Application number: 2026/62/90484/E	
What is the application for?:	Change of use from dwelling to C2 for 4 children, erection of first floor extens
Address of the site or building:	143, Church Lane, Gomersal, Cleckheaton, BD19 4QN
Postcode:	LS27 7HB

Proposed Site Layout 1:100

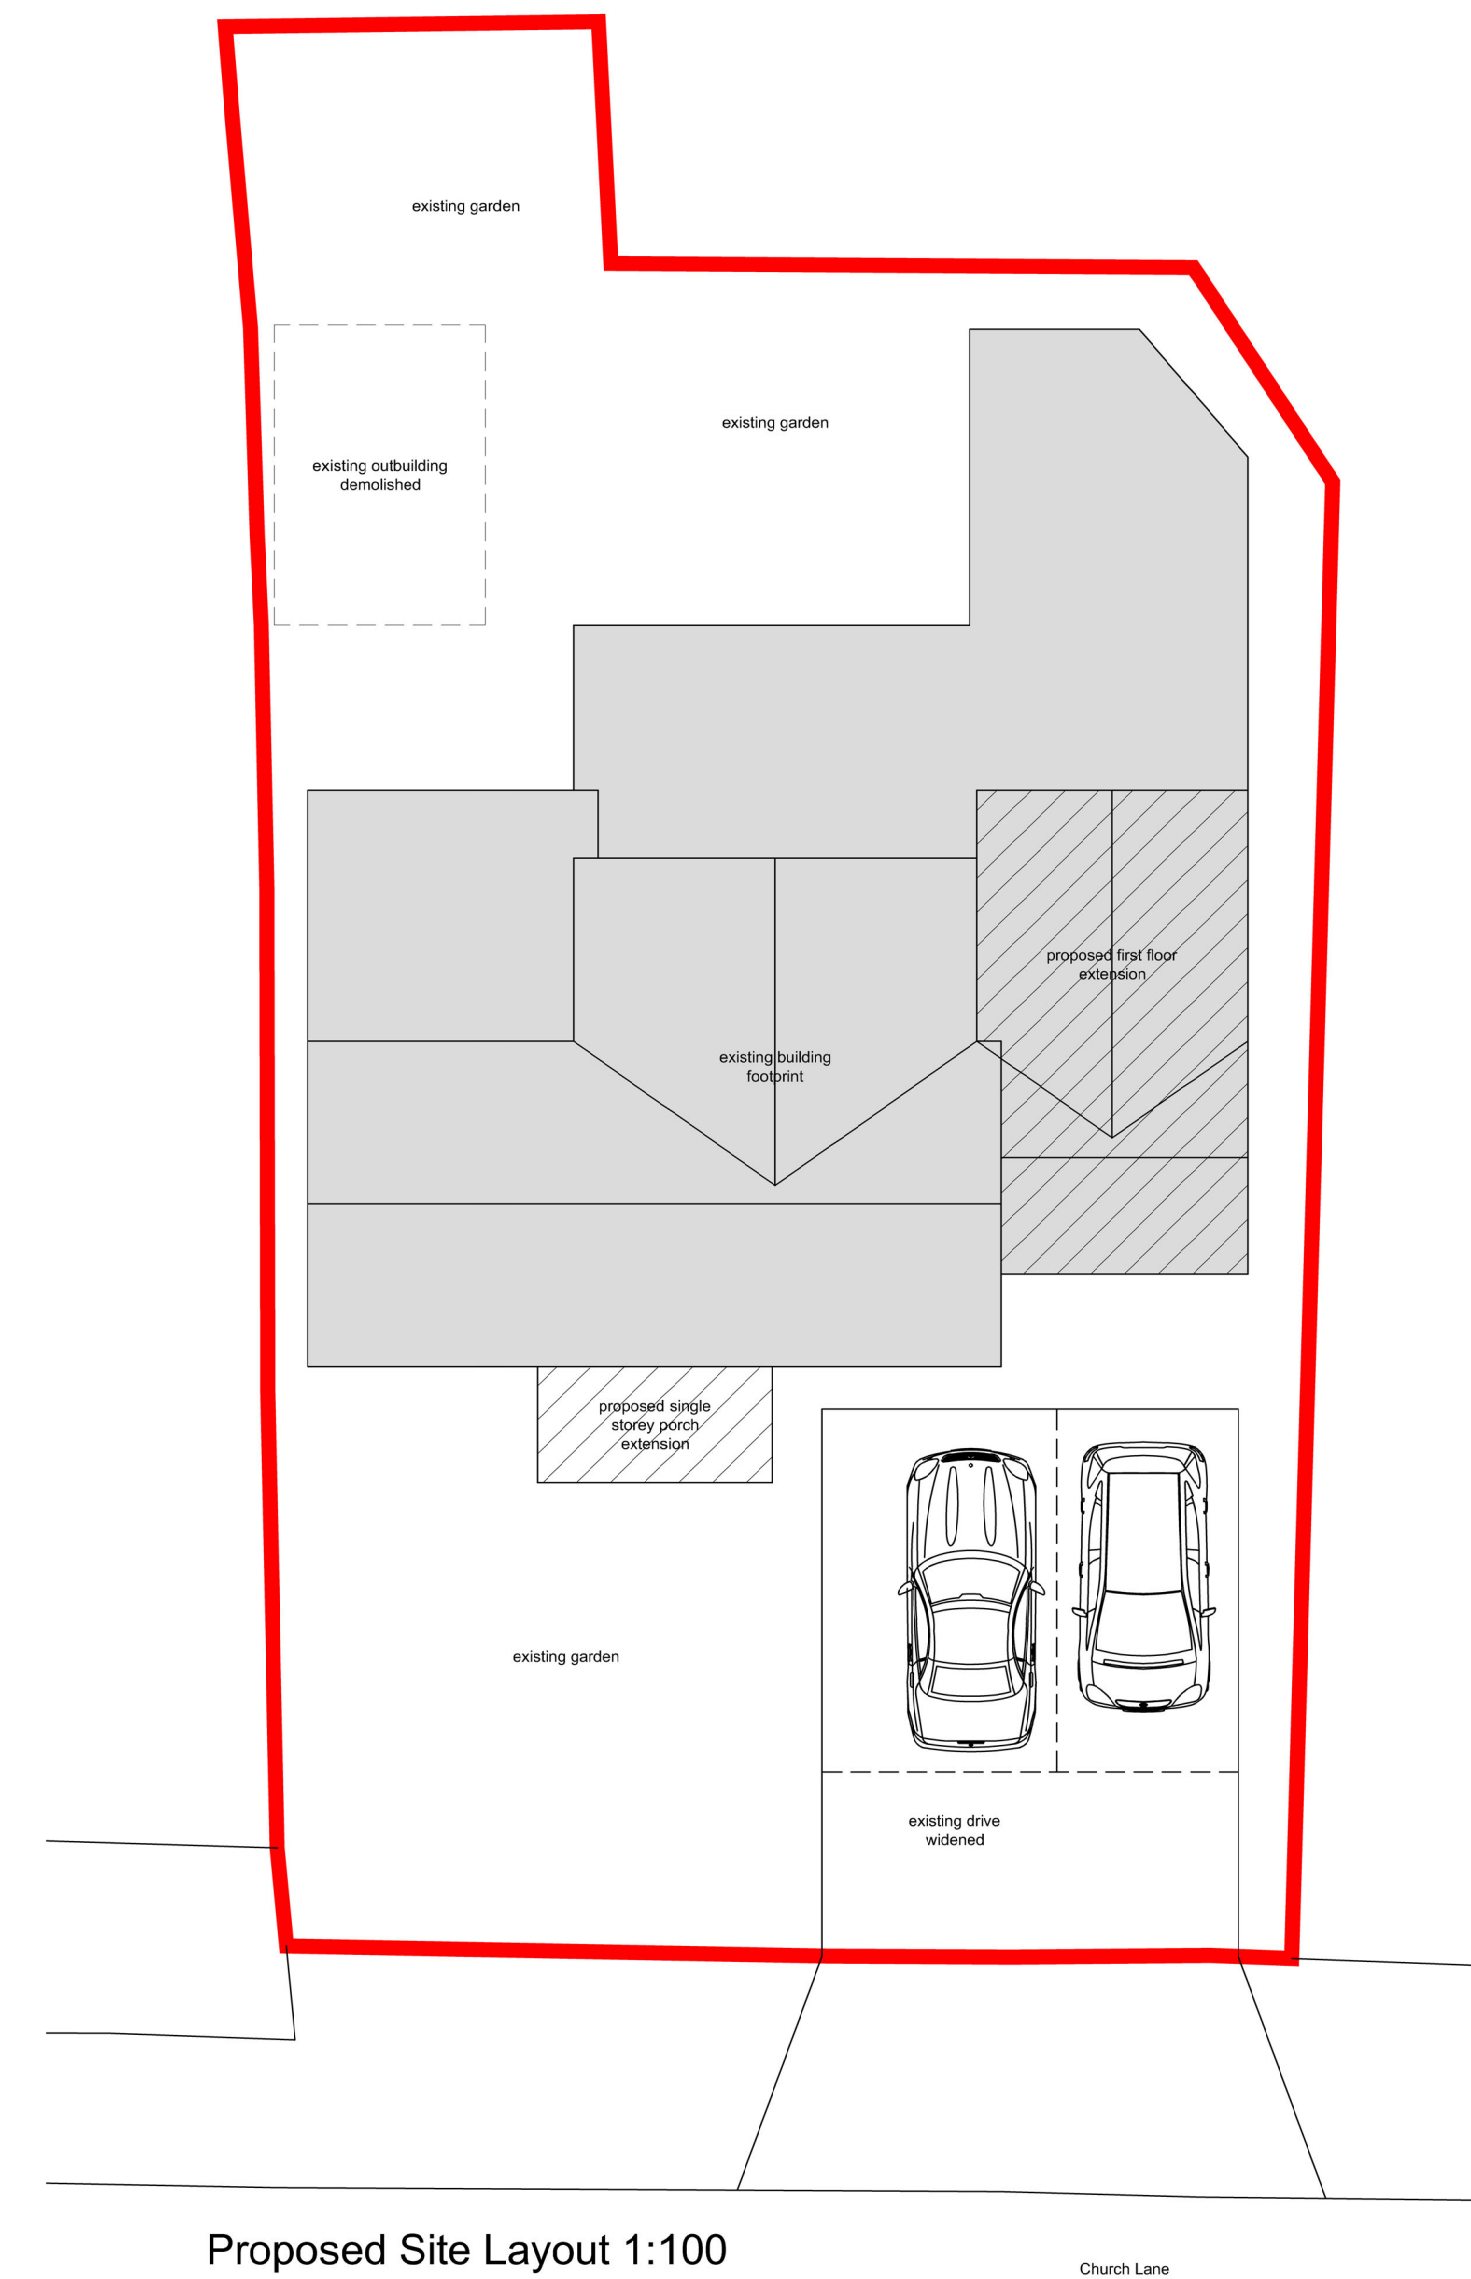
Type of comment: An objection	
Do you wish your comments to be published on the website anonymously?	Yes
I am writing to formally object to the proposed development at 143 Church Lane on the following grounds: 1. Inadequate Parking Provision and Highway Safety The proposal for only two off-site parking spaces is insufficient for the operational requirements of a residential children's home. Based on the submitted plans, the ratio of staff-to-children, alongside regular visits from family, social services, and delivery vehicles, will far exceed the on-site capacity. This will inevitably lead to overspill parking on Church Lane and The Coppice. Church Lane is already a high-volume road with documented issues regarding speeding and police enforcement. Increased roadside parking will create hazardous "blind spots," restrict traffic flow, and compromise the safety of both pedestrians and motorists. 2. Impact on Residential Amenity and Character The Coppice is a quiet, established cul-de-sac. The anticipated increase in non-resident vehicles and foot traffic will be detrimental to the "quiet enjoyment" and security of this residential area. This intensification of use is out of character with the existing immediate environment. 3. Privacy and Visual Dominance I have significant concerns regarding the height and scale of the proposed structure. The side elevation will result in a loss of privacy for neighbouring properties and create an overbearing visual impact. 4. Evidence of Existing Access Issues Current activity by developers has already demonstrated that the site cannot accommodate necessary vehicle volumes. Frequent roadside parking by contractors has already caused significant disruption. If the permanent application is approved, these temporary issues will become a permanent detriment to the local highway network. I respectfully urge the planning authority to refuse this application. I have photographic evidence to support my objection.
